**Preliminary Acceptance Punchlist**  
**El Paso County – Department of Public Works - Stormwater Section**

Project Name:	Solace of Colorado Springs
EDARP Filing Number(s):	CON2165, SF2032
ESQCP Number:	ESQ2142
Attendees:	<b>DPW Stormwater:</b> Natasha Grimaldo <b>DPW Development Services:</b> Brad Walters and David Parkerson <b>Developer:</b> Kelsey York and Manmit Jadav
Date of Walk-Thru:	01/31/2024
Walk-Thru Number:	1 <sup>st</sup>

SHEET 19 OF 32	SOLACE APARTMENTS FILING NO. 1	H-SCALE	3/4" = 1'	NO.	REVISION	BY	DATE
		V-SCALE	3/4" = 1'				
POND A DETAILS		DESIGNED BY	JBP	DATE	11/11/21		
		DRAWN BY	RPD				
		CHECKED BY

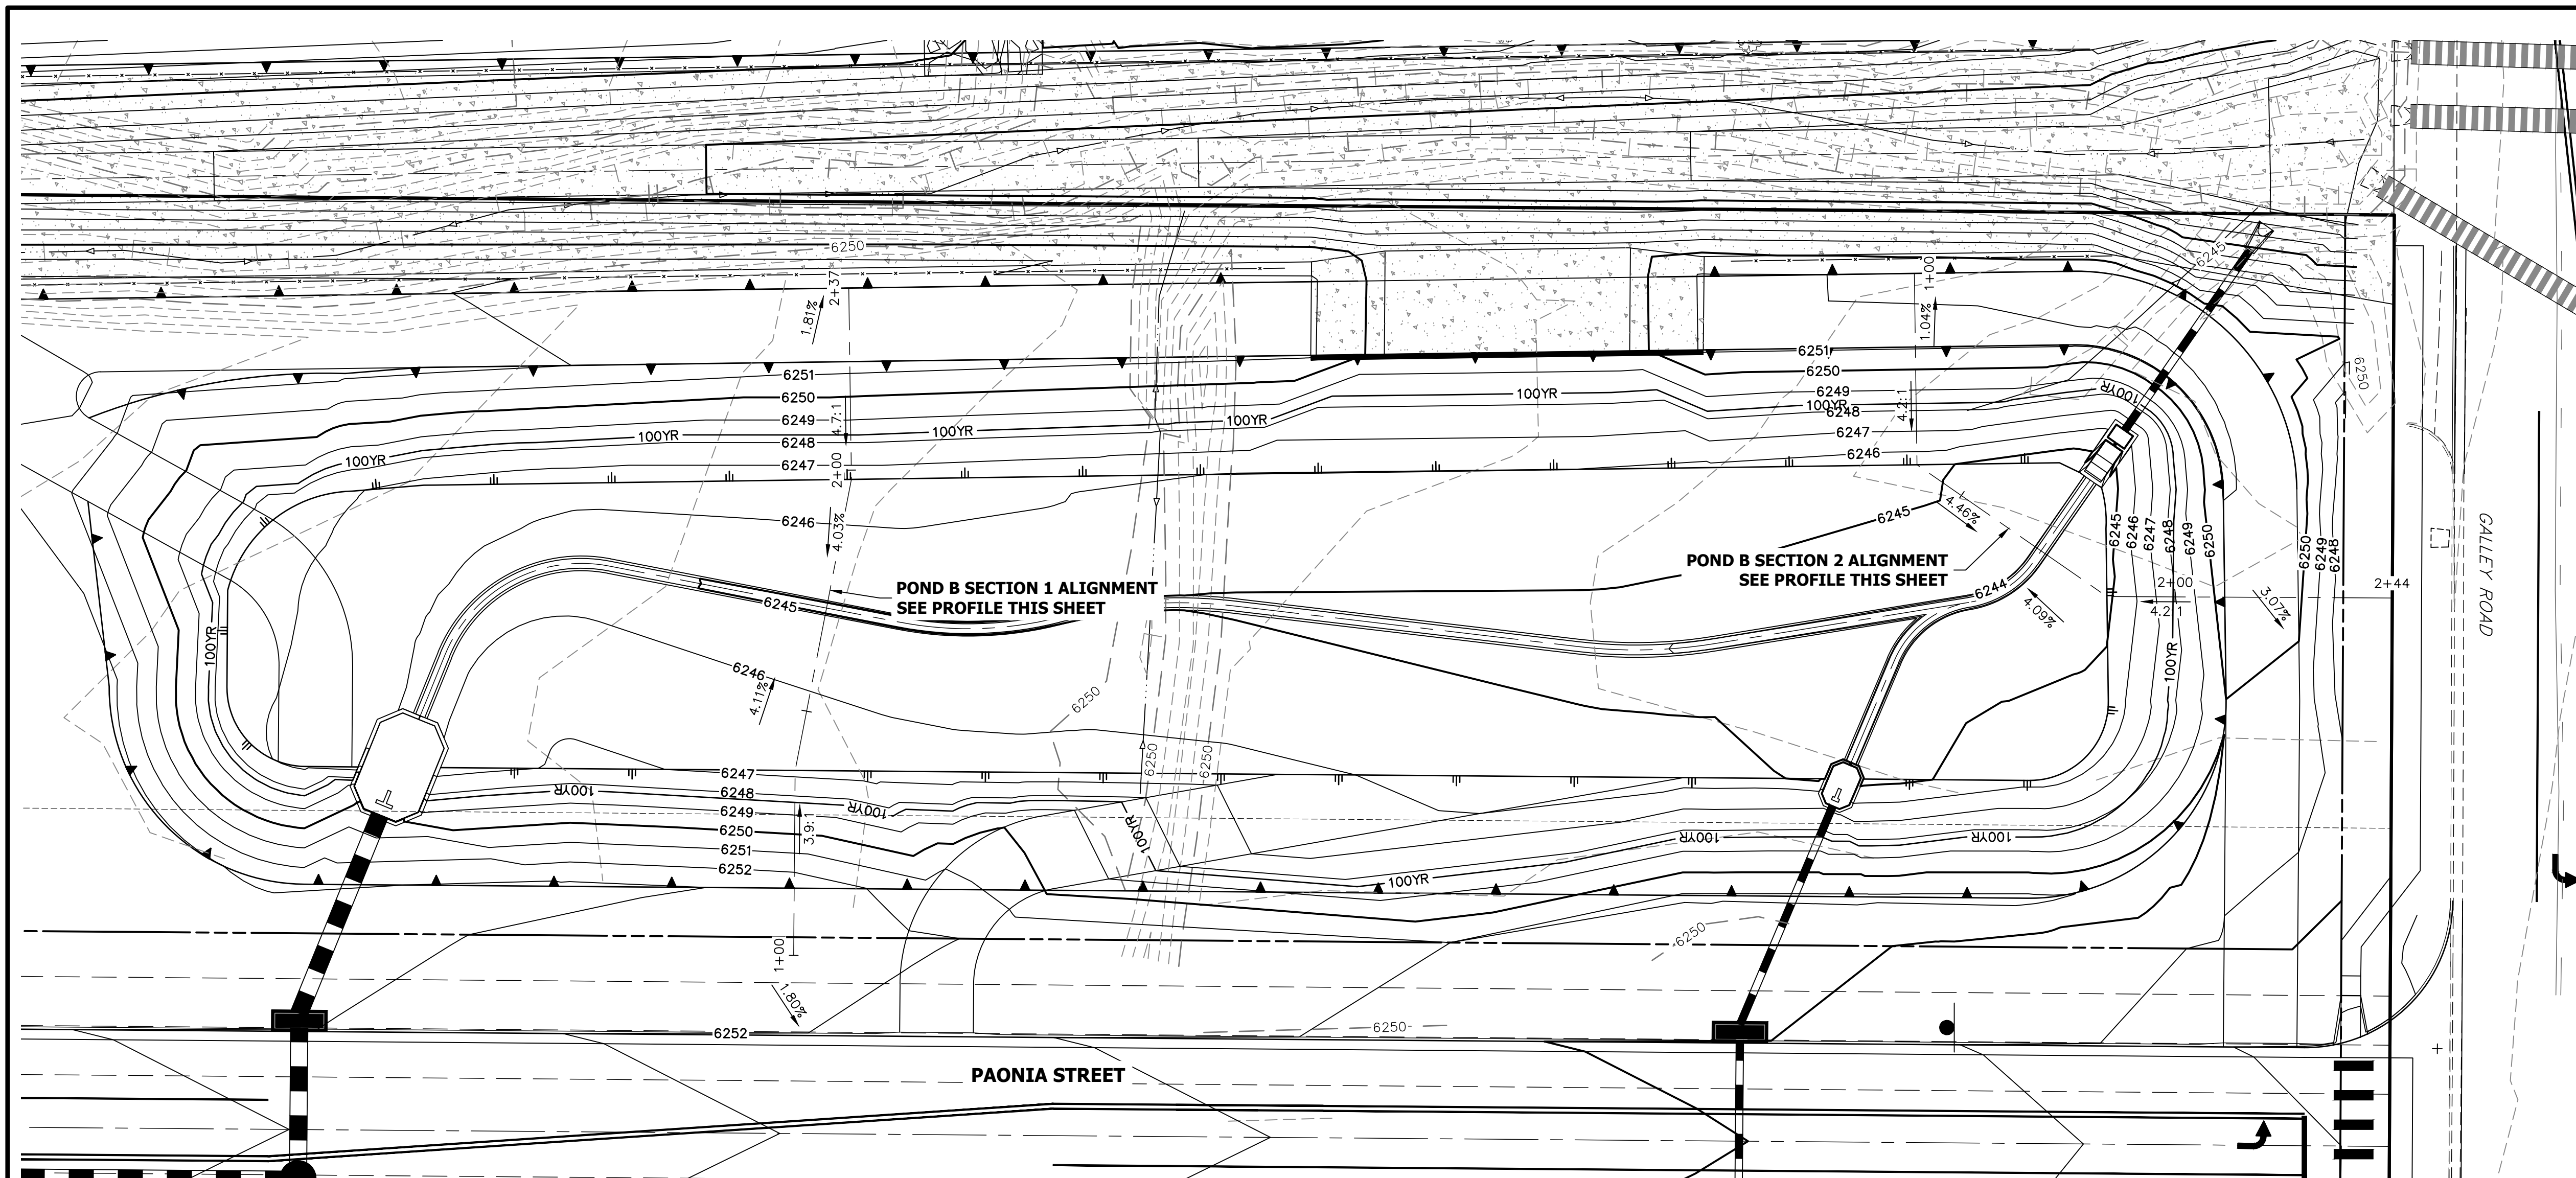
- Clean out sediment and debris from outlet structure and trickle channel.
- Failure to install properly sized trash racks. Reference Trash Screen Detail on Sheet 19 of the Construction Drawings. Reference Photo 16.

Photo 16: Pond A: Failure to install properly sized trash racks. Reference Sheet 19 of the Construction Drawings.
